INDIVIDUAL PLANNING OBJECTION

Waterloo South SSDA — SSD-93222706

5/237 Cope Street, Waterloo NSW 2017 — PT 20 — SP79210

Sawtooth Warehouse Conversion — 237 Cope Street | Individual Objection Template | Deadline: 5:00pm Tuesday 2 June 2026

Drawing Name
Blocks 2 & 3
 Proposed Envelope -
 3D Diagram

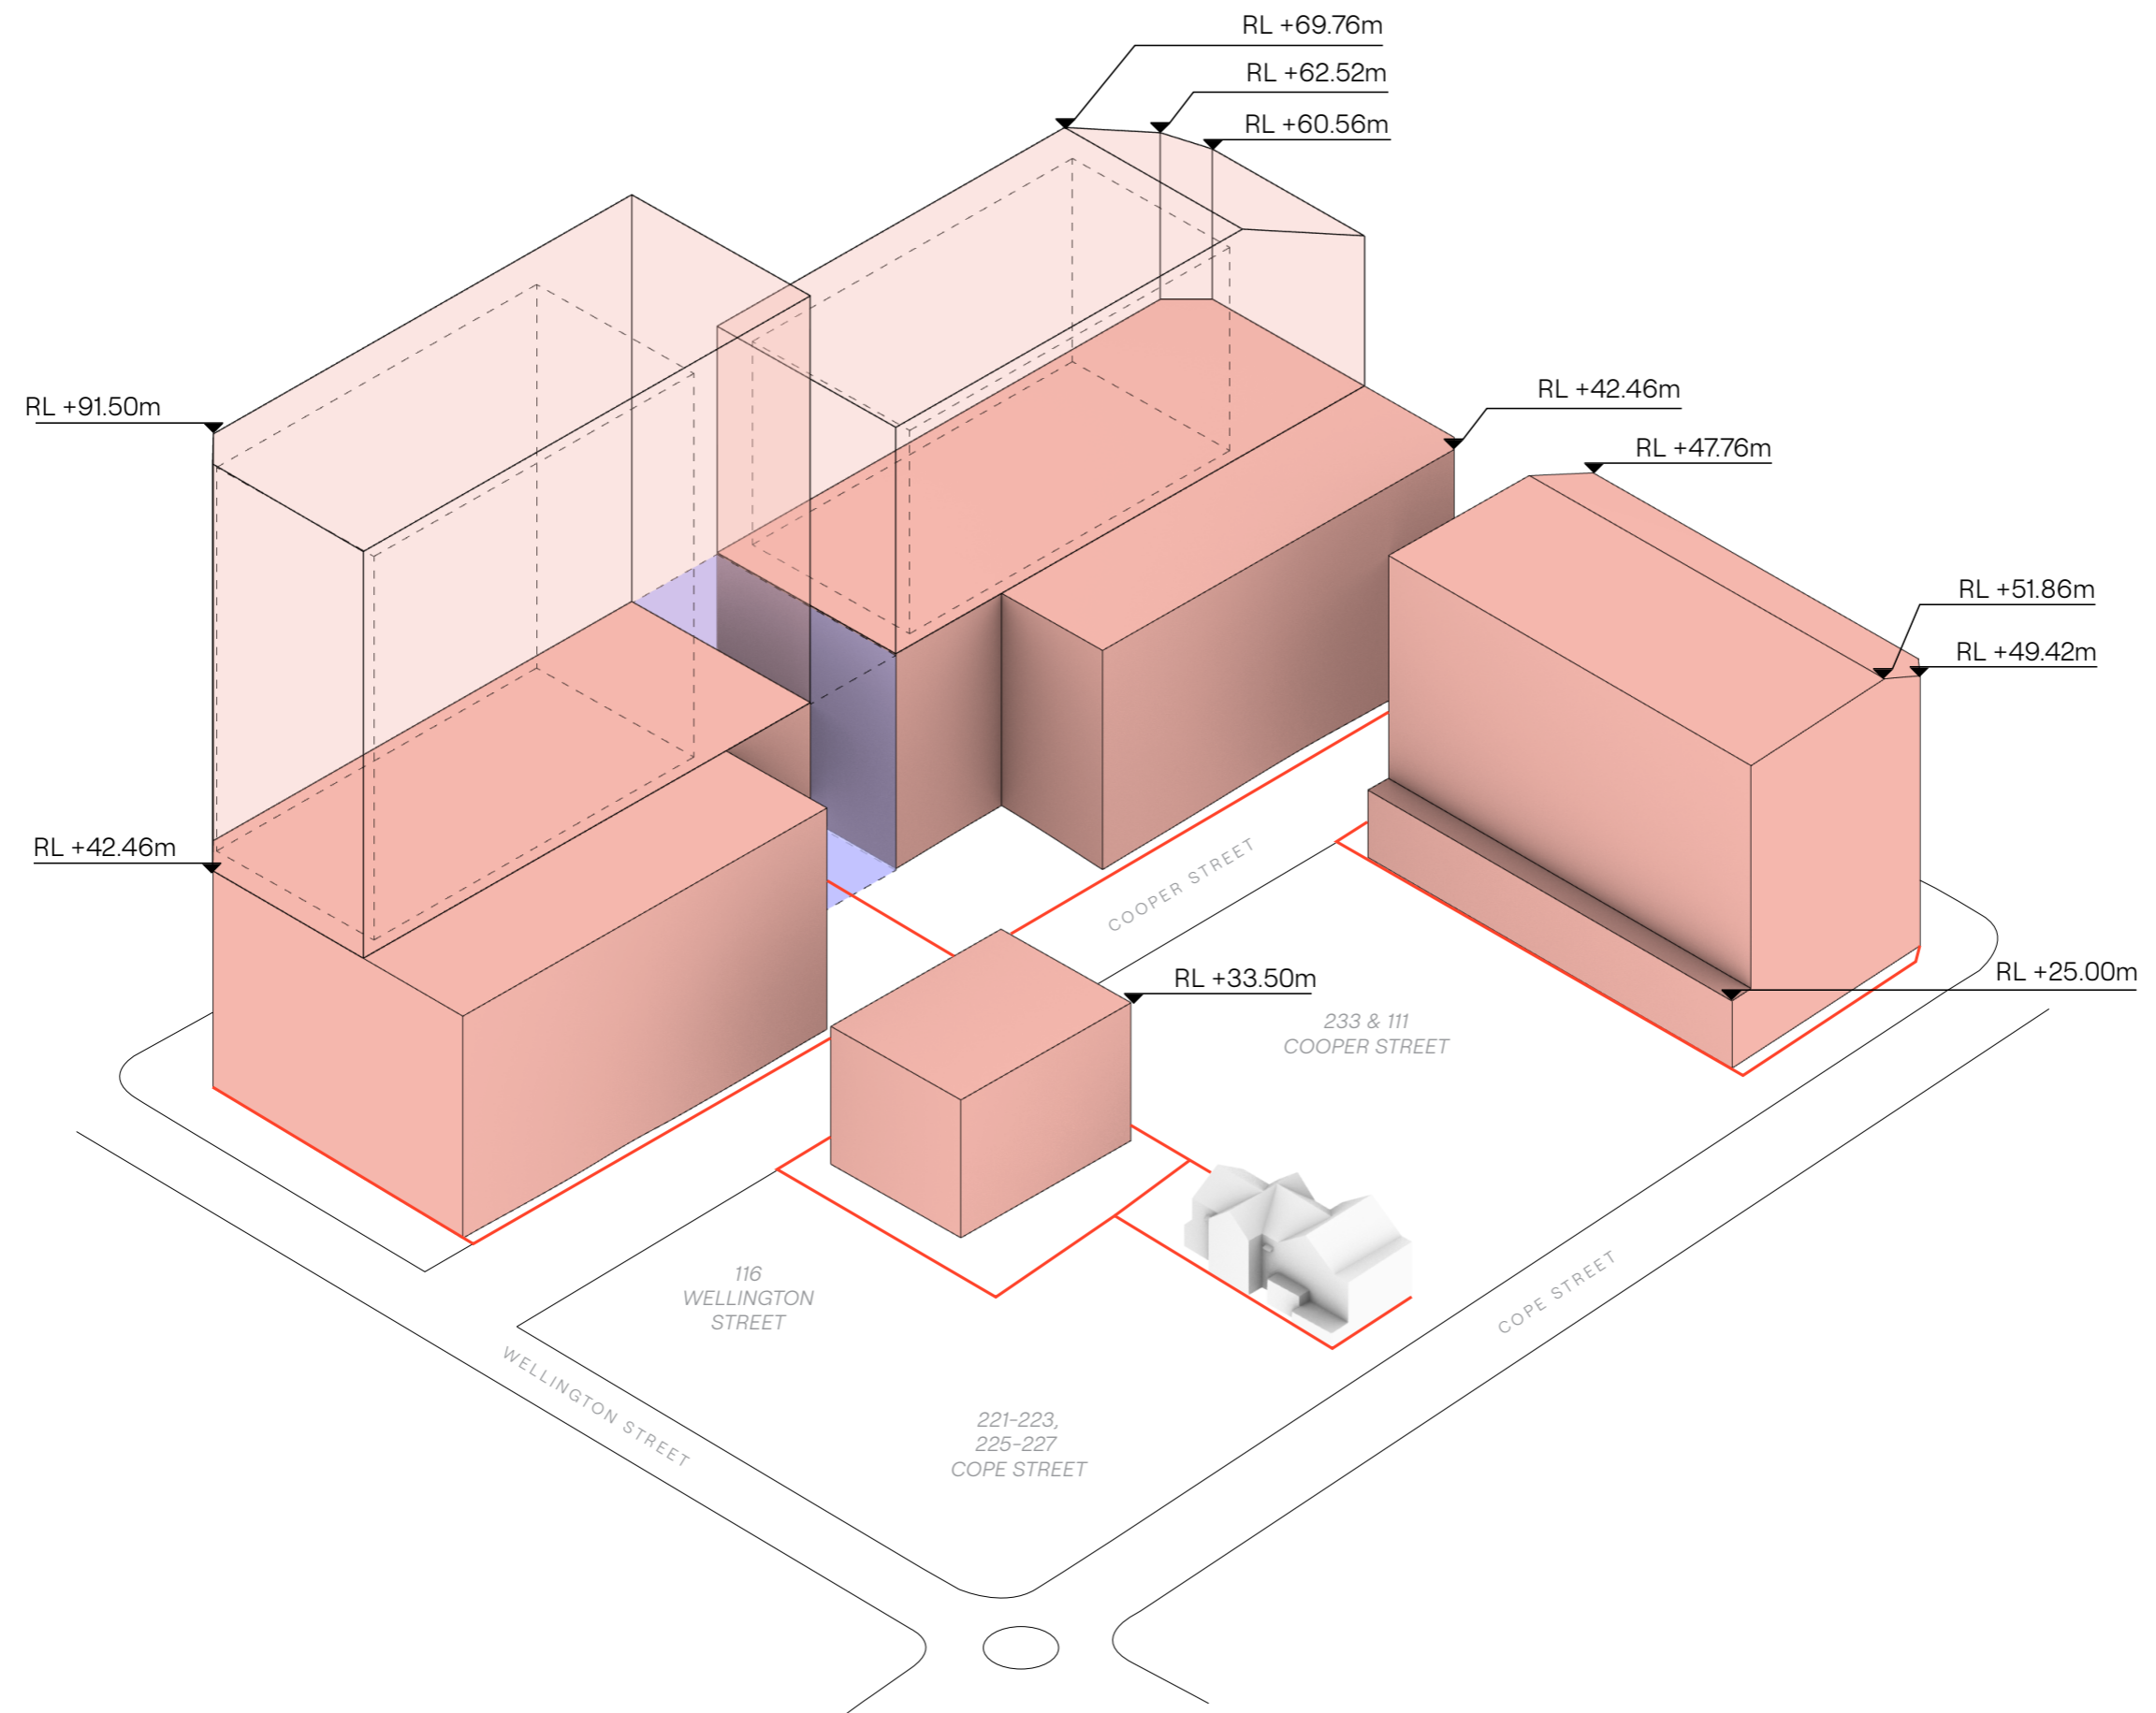
- **Loss of solar access:** The proposed Lot 2D (9 storeys, RL +51.86m, 3m setback from Cope Street) is positioned directly opposite my building. The EIS Urban Design Report confirms Cope Street receives between 0 and 1.75 hours of winter solstice sunlight under the proposed envelopes. No solar access analysis has been conducted for privately owned properties on the western side of Cope Street in breach of SEAR 7.

- **237 Cope Street — architectural solar dependency:** The sawtooth clerestory glazing and apex skylights of my unit are entirely dependent on unobstructed eastern morning solar access (threatened by Lot 2D) and southern sky access (threatened by Lot 3B on John Street, RL +69.76m). Blocking these specific light sources eliminates the architectural character and habitability of my dwelling. This is not a generic overshadowing impact — it is an architectural nullification.

- Require supplementary solar access analysis modelling overshadowing of my property at hourly intervals between 9am and 3pm as required by SEAR 7
- Require a supplementary Visual Impact Assessment with viewpoints from within my property and other privately owned properties on Cope Street
- Require the proponent to provide the comparative analysis of the two-storey height protection removal required by SARP Study Requirement Item 3
- Require a Construction Environmental Management Plan addressing impacts on privately owned properties on Cope Street prior to demolition or excavation
- Appoint the Independent Planning Commission as consent authority
